The Engineering Heritage Committee of Sydney Division of Engineers Australia comments on the currently exhibited proposal for Windsor Bridge replacement as below.

Application Number: SSI – 4951

Submitted by: Engineering Heritage Committee,
Sydney Division, Engineers Australia.

Figure 5-1 | Key project elements

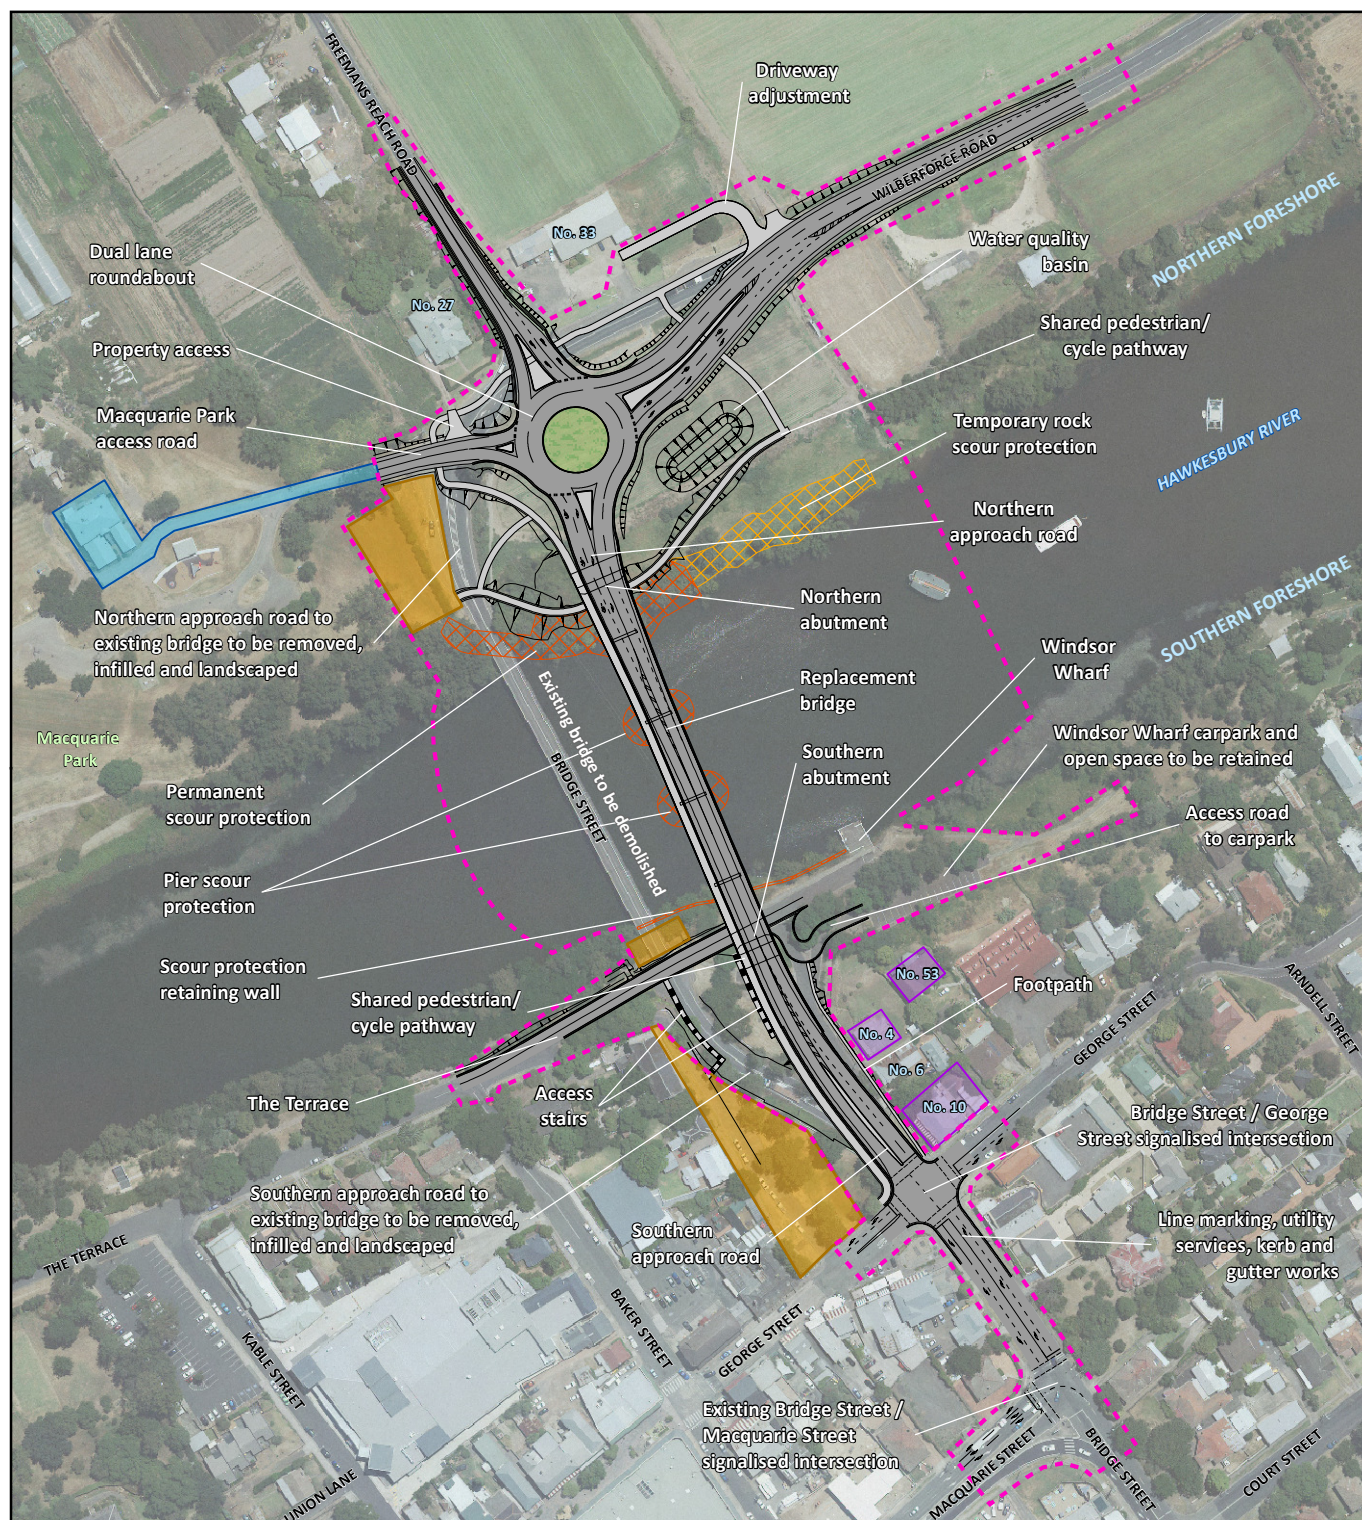
3. Based on the accumulation of information that has come to light in recent times, it is now apparent that the dismissal of "Option 7" (blue line, via North Street) was an error of judgment. Using this option takes the route outside the Windsor central precinct and also greatly alleviates the horrendous traffic and safety problems at the George Street roundabout which would not allegedly be fixed until some distant Stage II of the existing proposal, well into the future. Some adverse opinions to Option 7 have been expressed on the grounds of landscape deterioration but the quality of the existing landscape around Option 7 makes this difficult to discern. The cited speed of traffic is 60 km/h so that a curve of 80 metres radius at the intersection of Court Street and Windsor Road would just fit in immediately north of the bridge to conform to Austroads guidelines. A similar curve would, of course be required at the intersection of North Street and Palmer Street. This committee has strong preference for "Option 6" (red line) originally displayed but certain difficulties are recognized. Firstly the route of the option -- as shown --

passes too close to the Tebbutt Observatory. Secondly, there is the need for another bridge. However, considering what is at stake in this project, an additional cost, within the bounds of reason, is justified.

Graphitisation and Cracking of Piers

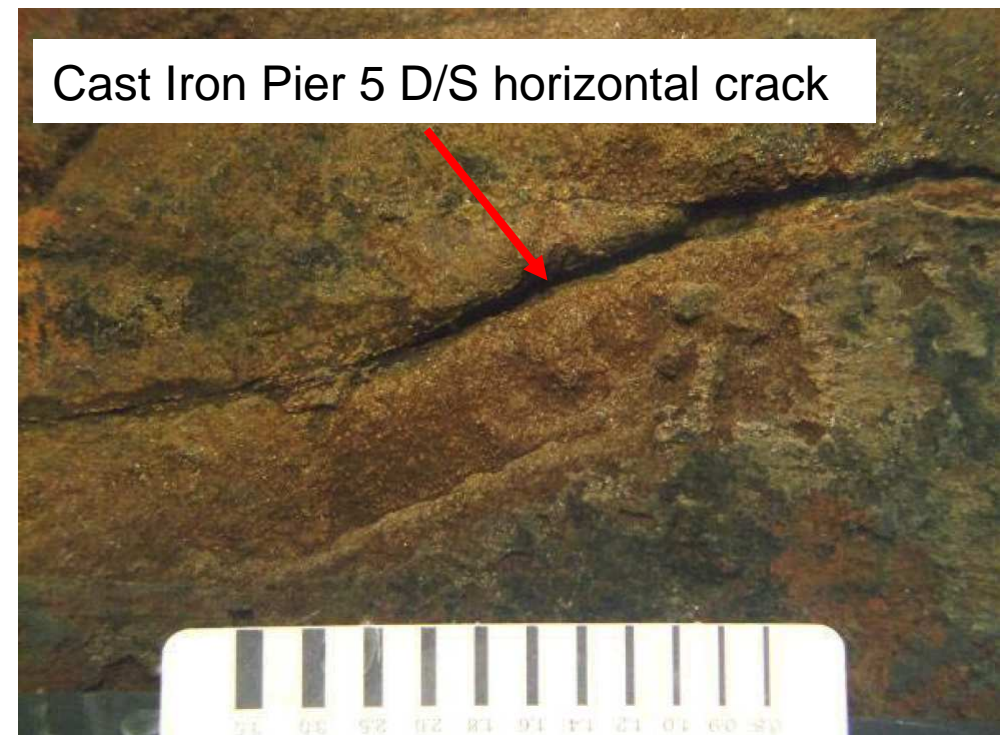
The cast-iron piers, from the previous century, also have substantial heritage merit. Other sources have suggested means of overcoming the graphitization damage so that the bridge would be enabled to be used at very least for traffic of light loading. In the event that the bridge is demolished, the mandatory archival recording of the State significant structure should be augmented by the preservation of at least one of the concrete beams for display and signage nearby, as in the case of similar previous projects.
